From: Brian Banister
Sent: 01 June 2009 09:40
To: Planning.Responses
Subject: RE: Planning Consultation on: LU/71/09/

APPLICATION LU/71/09/
NO:

Registered: 17-APR-09
Site 7& 9 Norfolk Road Littlehampton
Address:

Description of Works: Alterations to frontage and interior to change use of two existing shops to form two new residential units. (Re-submission following LU/7/09/)

West Elevation to Norfolk Road

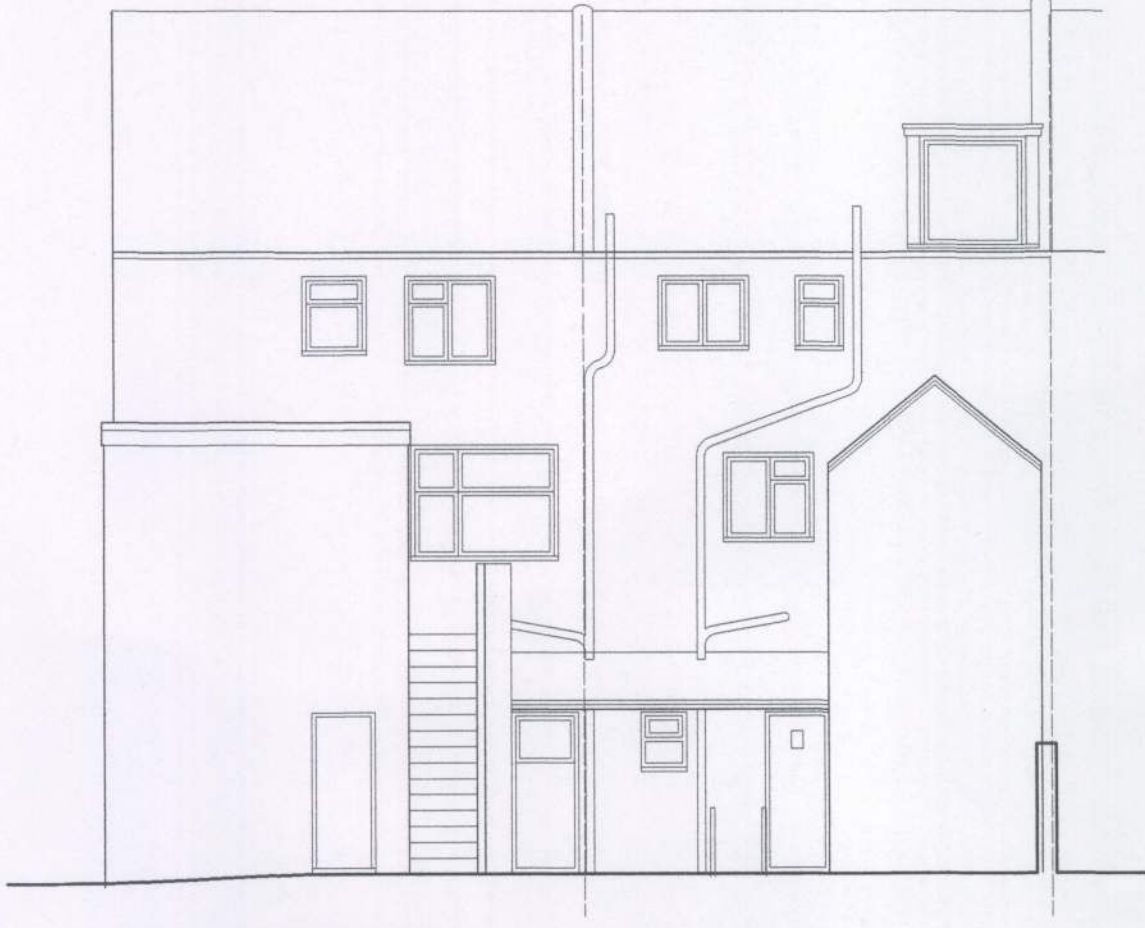
Its a pity to lose the retail uses but I should imagine this would be difficult to resist.
 New doors and windows need to be well recessed to match the existing. Is it possible to avoid top-hung PVCu sash windows. I would prefer painted timber vertical sliding sashes but if you consider it will be difficult to avoid PVCu because of the existing windows in the property then let's at least have vertically sliding sash PVCu windows.
